**Consultation Response from KC,  
Trees**

**2023/91491 Prickleden Mills, Woodhead Road, Holmfirth, HD9 2JU**

**Date Responded: 11/08/2023**

Appendix 1 Tree works

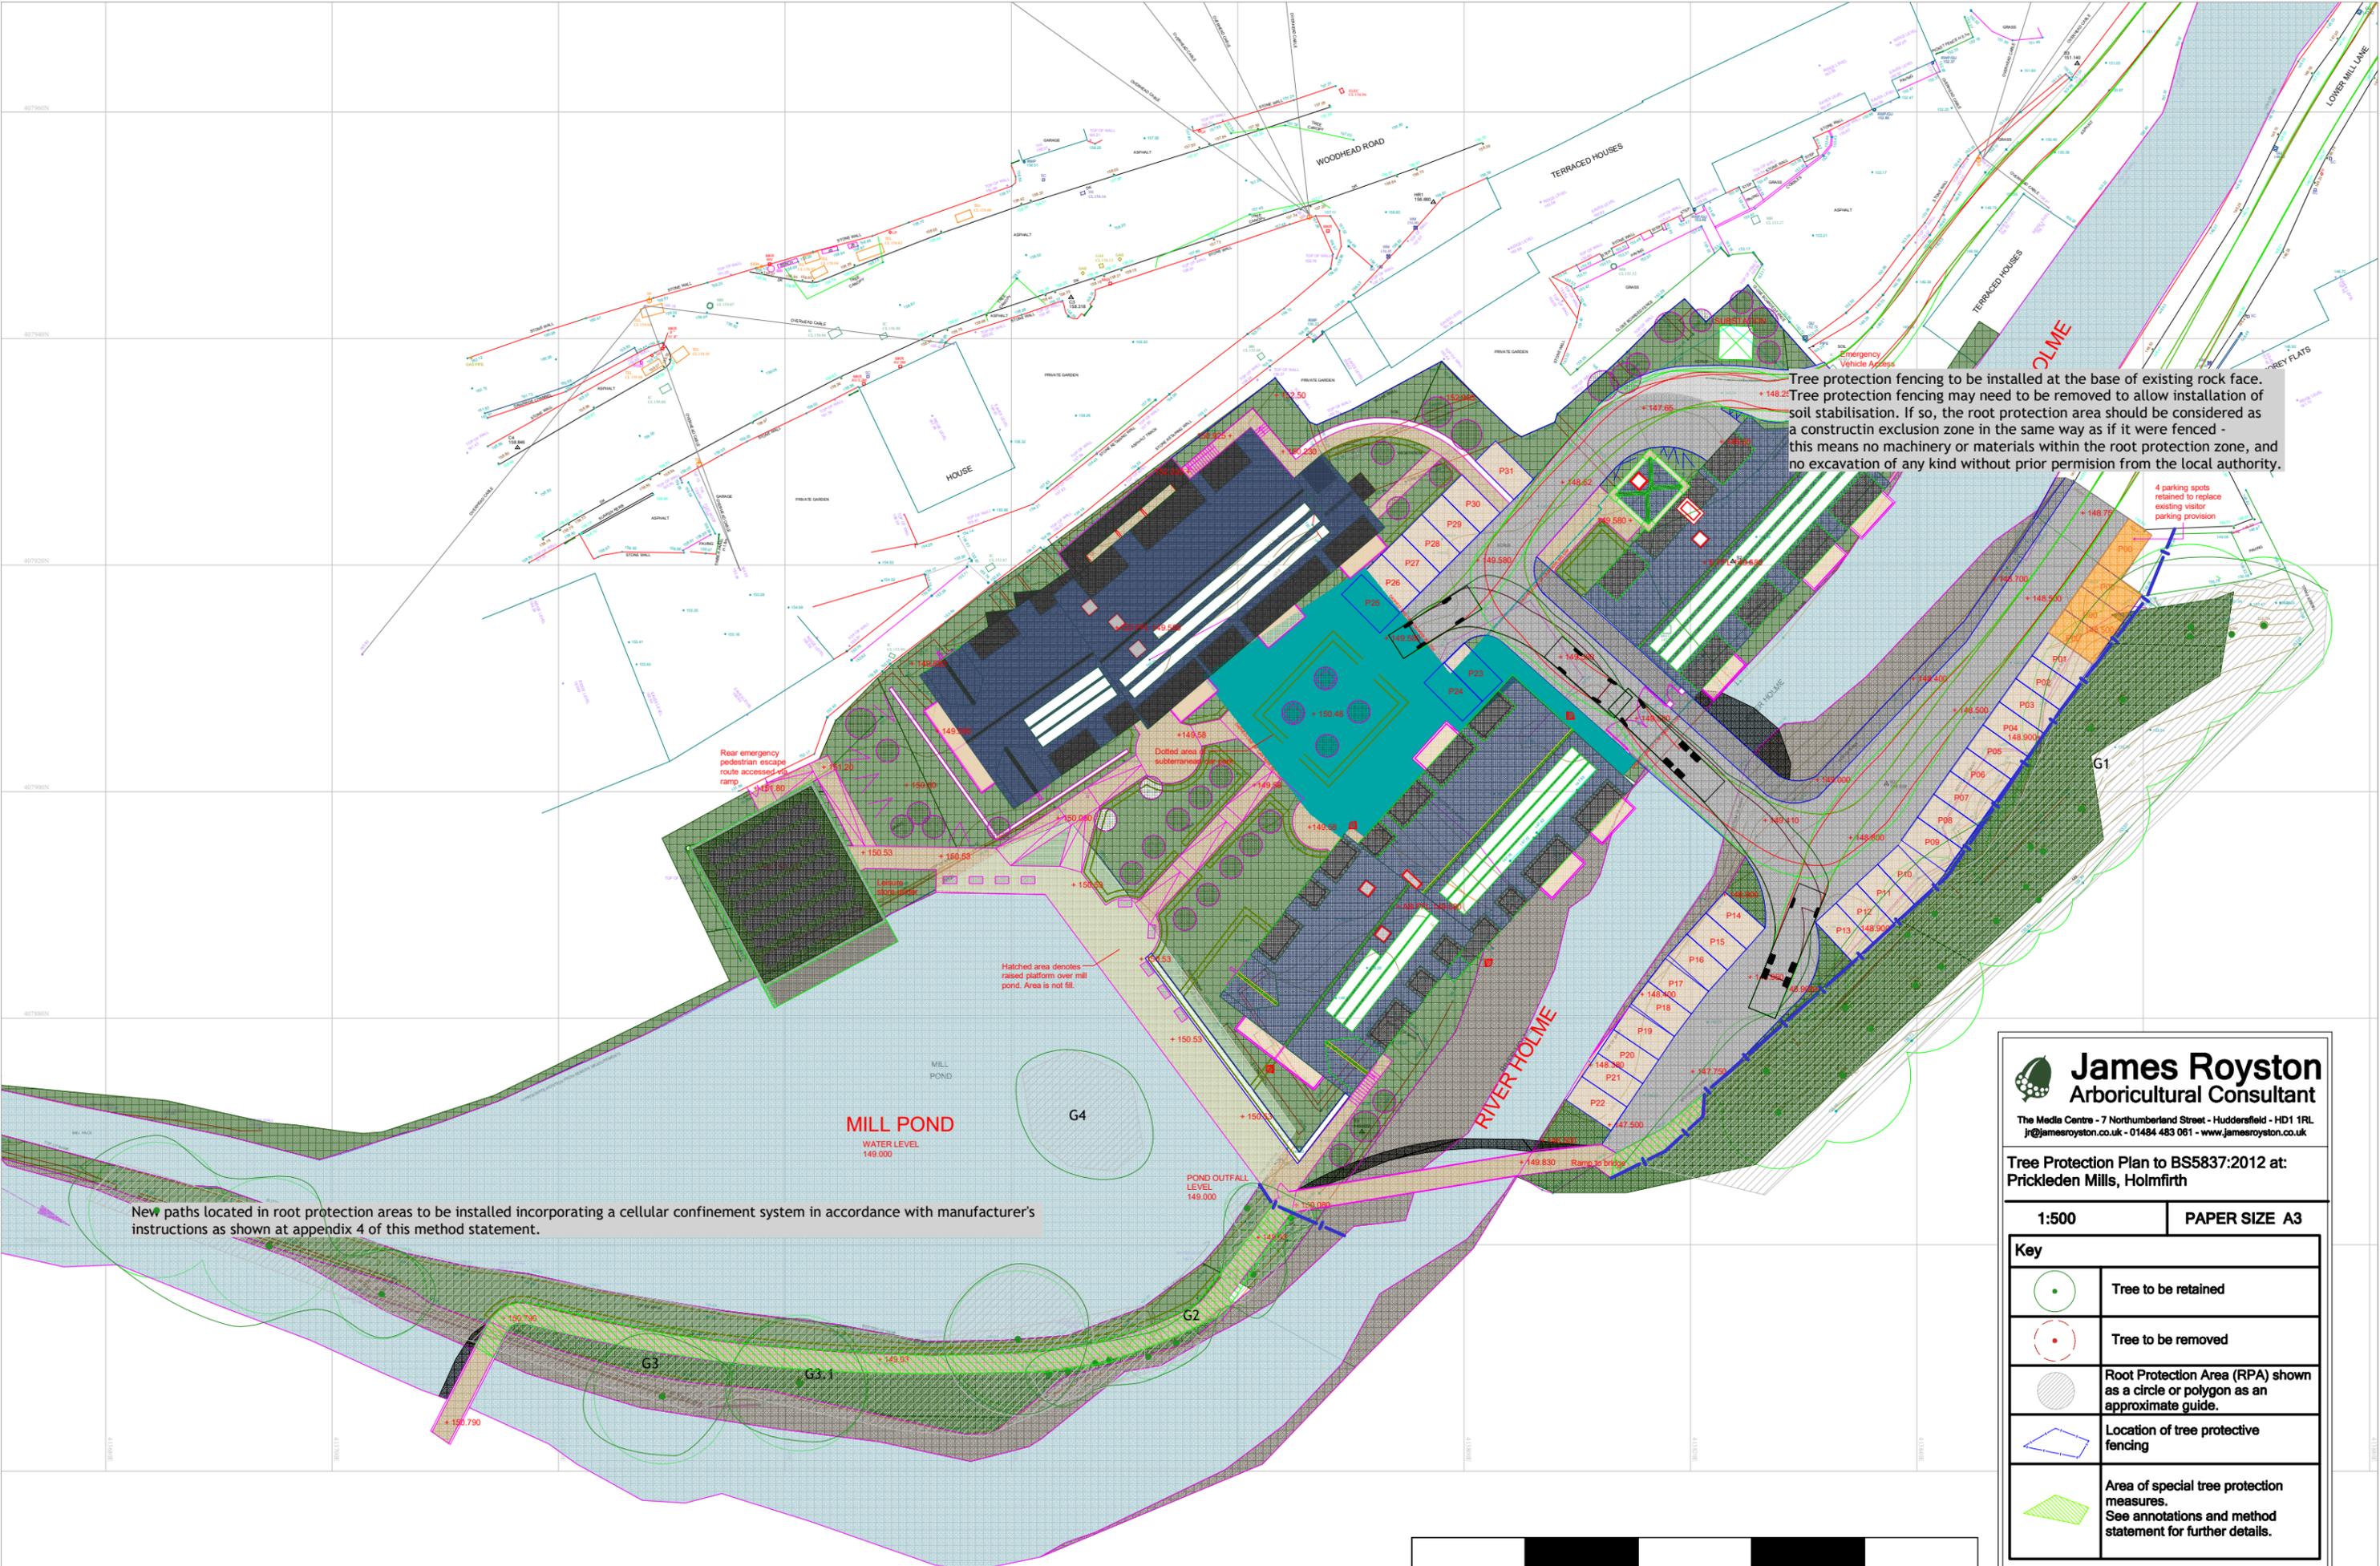
Please can trees team have clarification and details of the soil stabilisation that is proposed to be undertaken adjacent to the protected trees, marked as G1 in the tree survey (Ref 230614) and Arboriculture Impact Assessment (AIA) (Ref 230614 AIA).
